From: Maria Tomalova
Sent: Wednesday, July 6, 2022 10:21 AM
To: Peter Cleveland [REDACTED]
Subject: RE: Stakers Farm

Further to our call last week and the email below, please find attached the amended drawing which addresses the request for brickwork in the cart store opening. I hope this now addresses the comments from Martin.

I would be grateful if the attached to the file as a substitute to drawing no. 1020-06B – proposed elevations.

BARNS 1&2 PROPOSED SOUTH EAST ELEVATION
SHOWING SHUTTERS OPEN

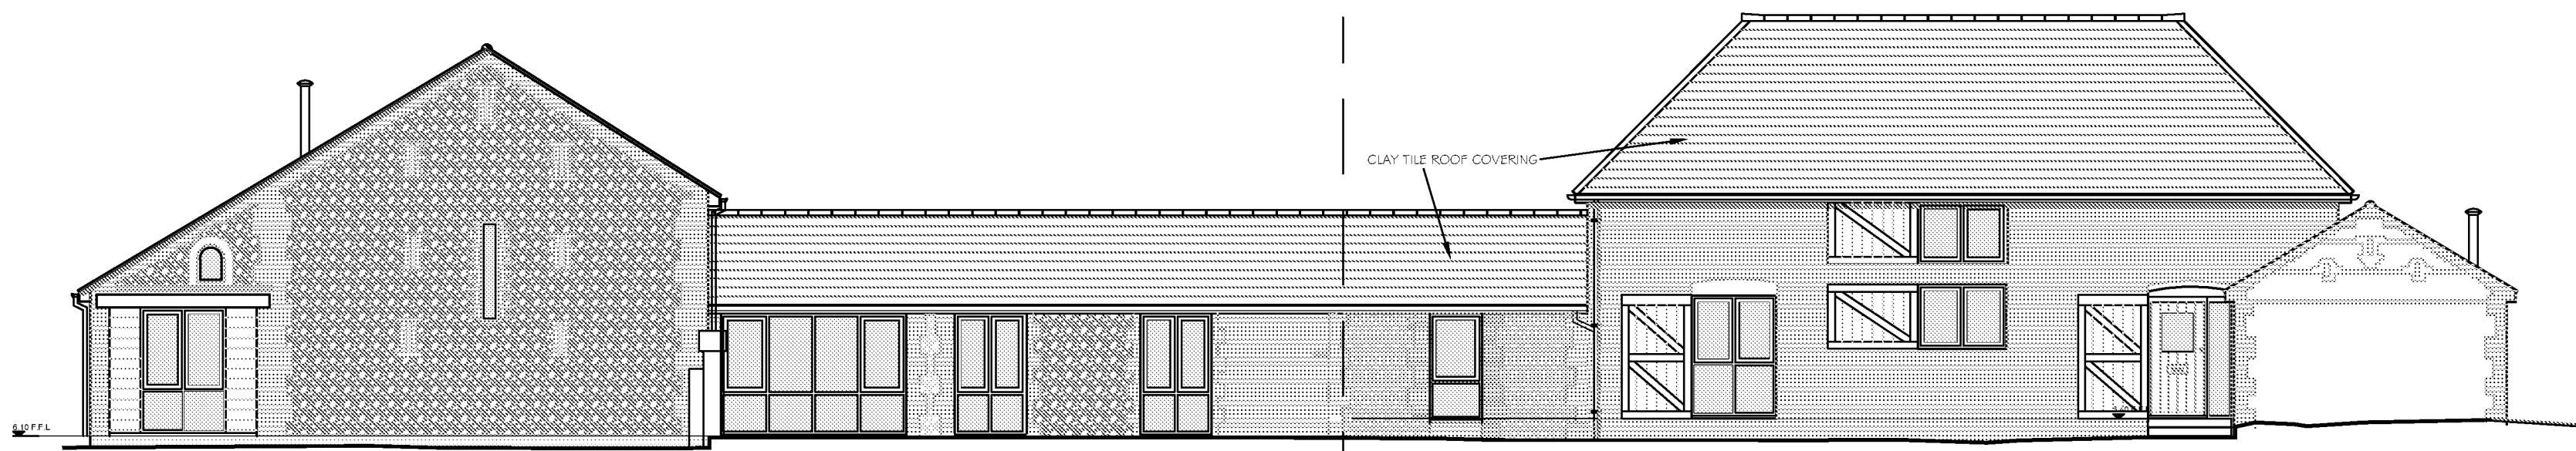
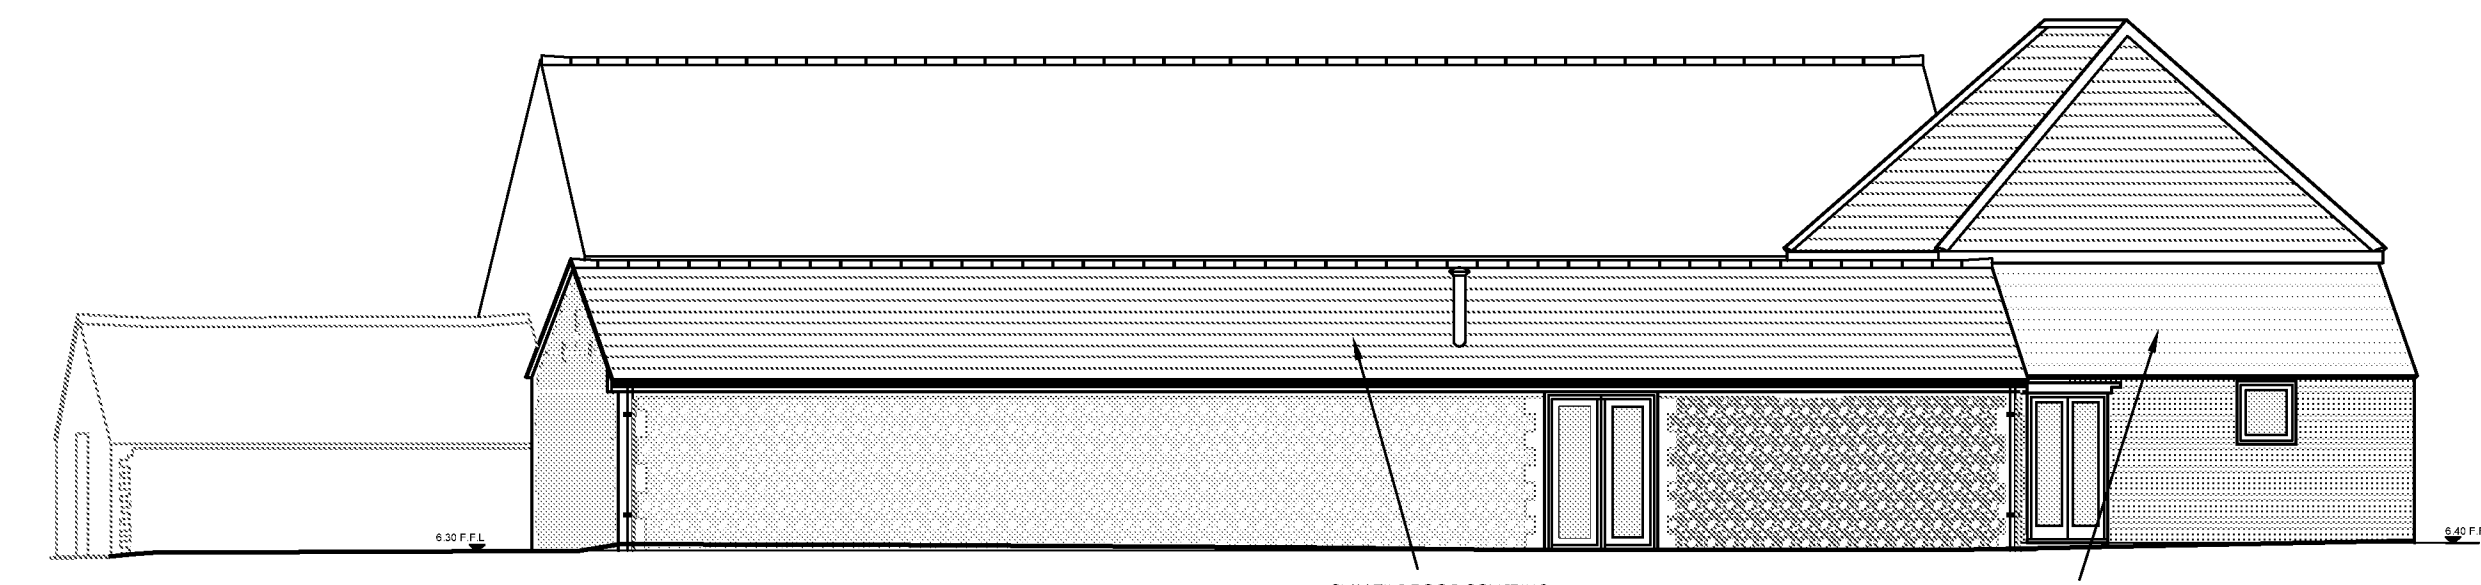
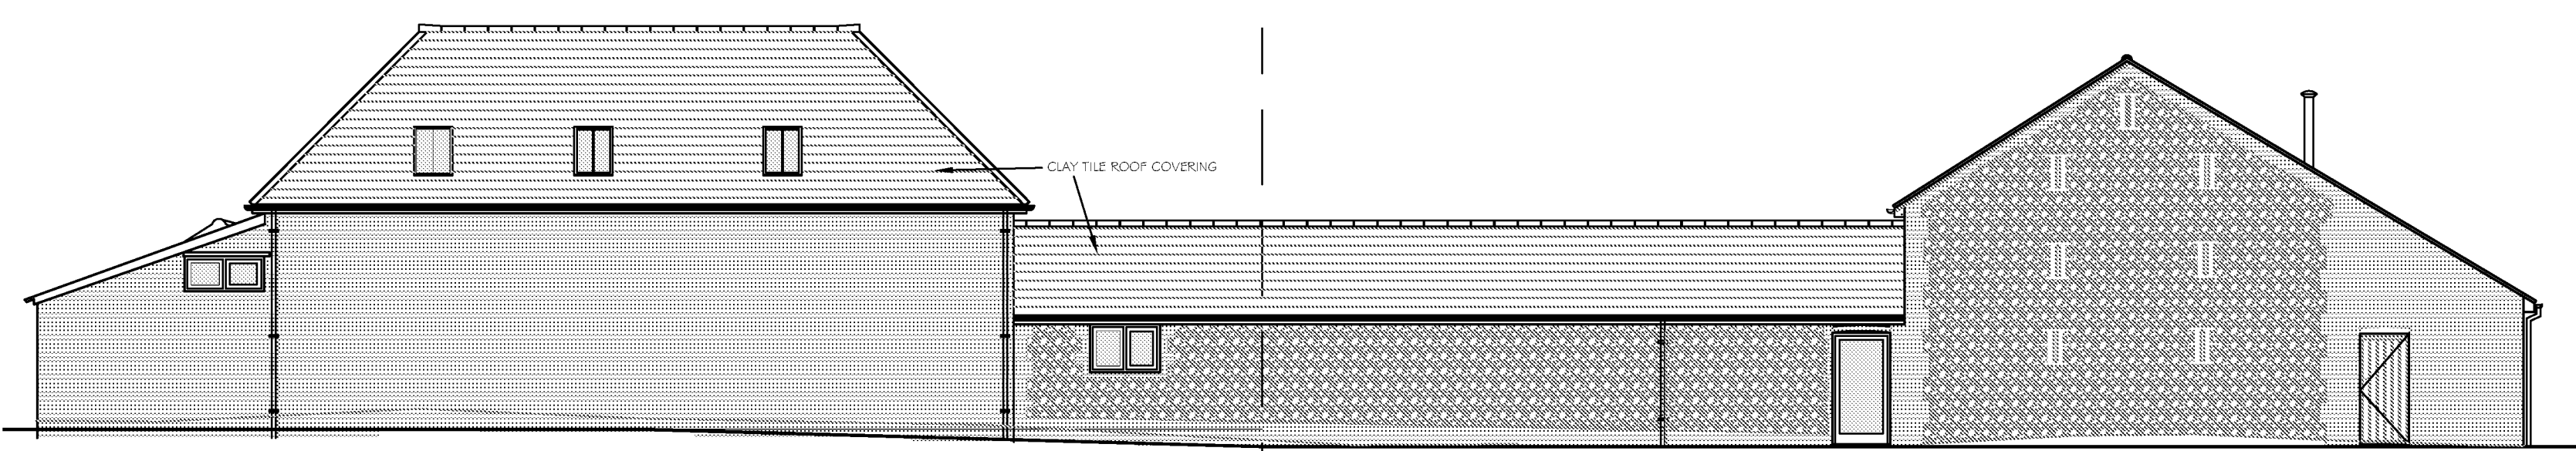
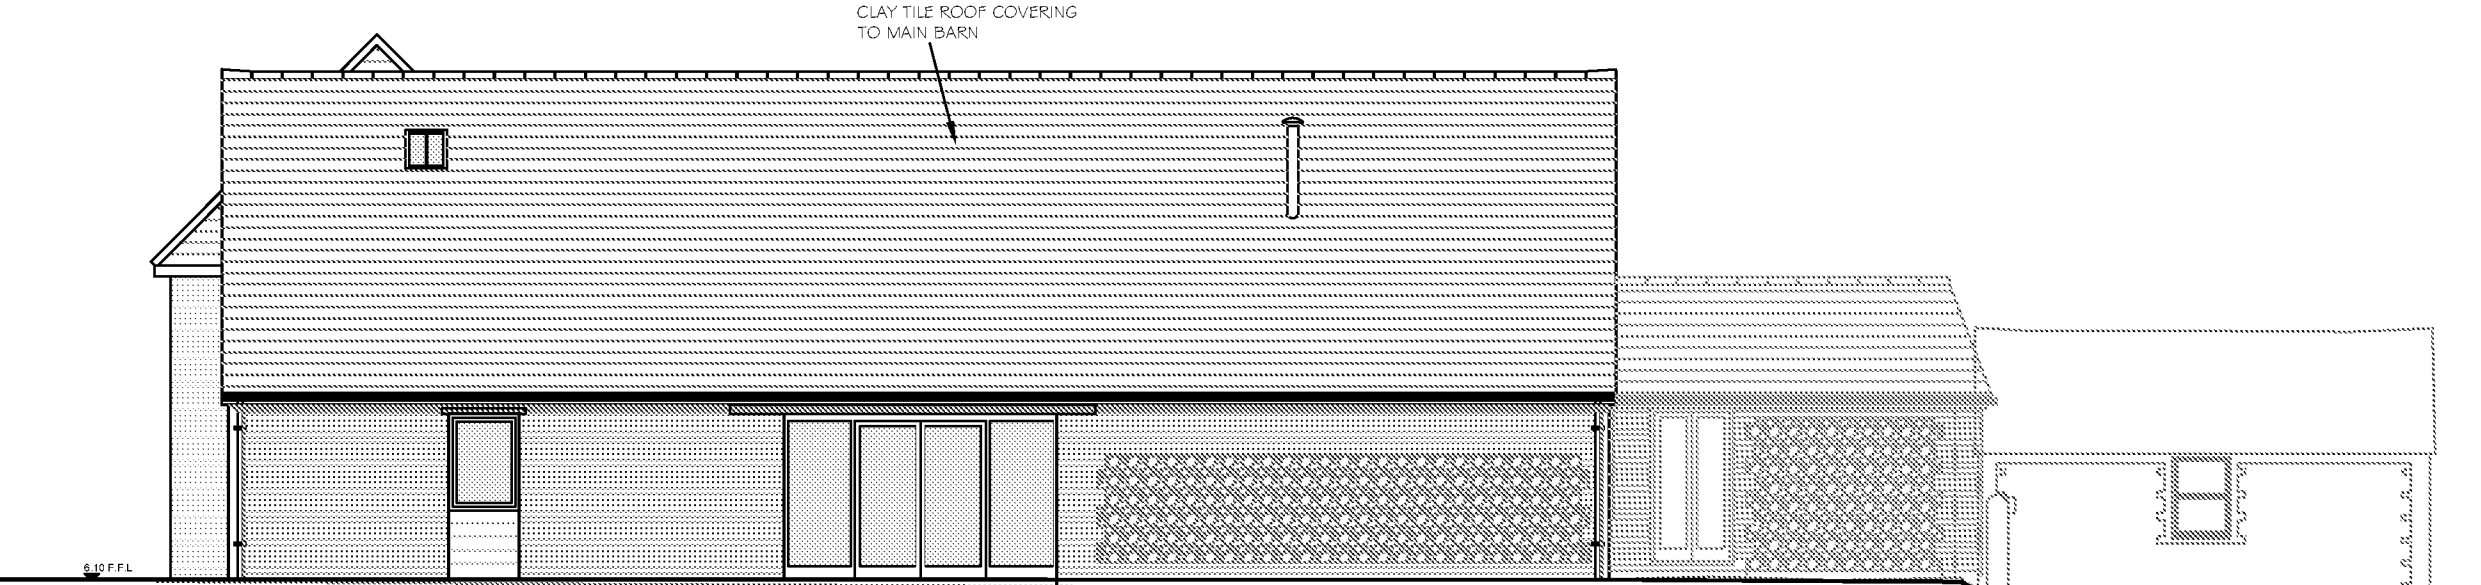
1. Altered proportions of window on the south-east elevation with the proportional split of openings to be circa 2/3 for the opening and 1/3 for the low level fixed frame
2. Width of fenestration on outshot to the side of the main barn reduced to 2 pane widths.

- Barn 2 potential for window to dominate the elevation - As shown on the attached photo, this is an original cart shed opening which has previously been crudely infilled with brickwork and a door. The original timber beam above the opening is still in position, and this will be retained and used as the top of the reinstated opening. The removal of the door and infilled brickwork will reinstate the original opening, and this will be clearly expressed with a simple, full height glazed screen.

- Barn 1 south east elevation - The proposed windows to the south east elevation of Barn One are all within existing openings and would all serve bedrooms. We have now omitted the horizontal boarding to the window serving bedroom 3 and shown this as full height glazing to match the other proposed windows. Can window details be dealt with via condition if needed?
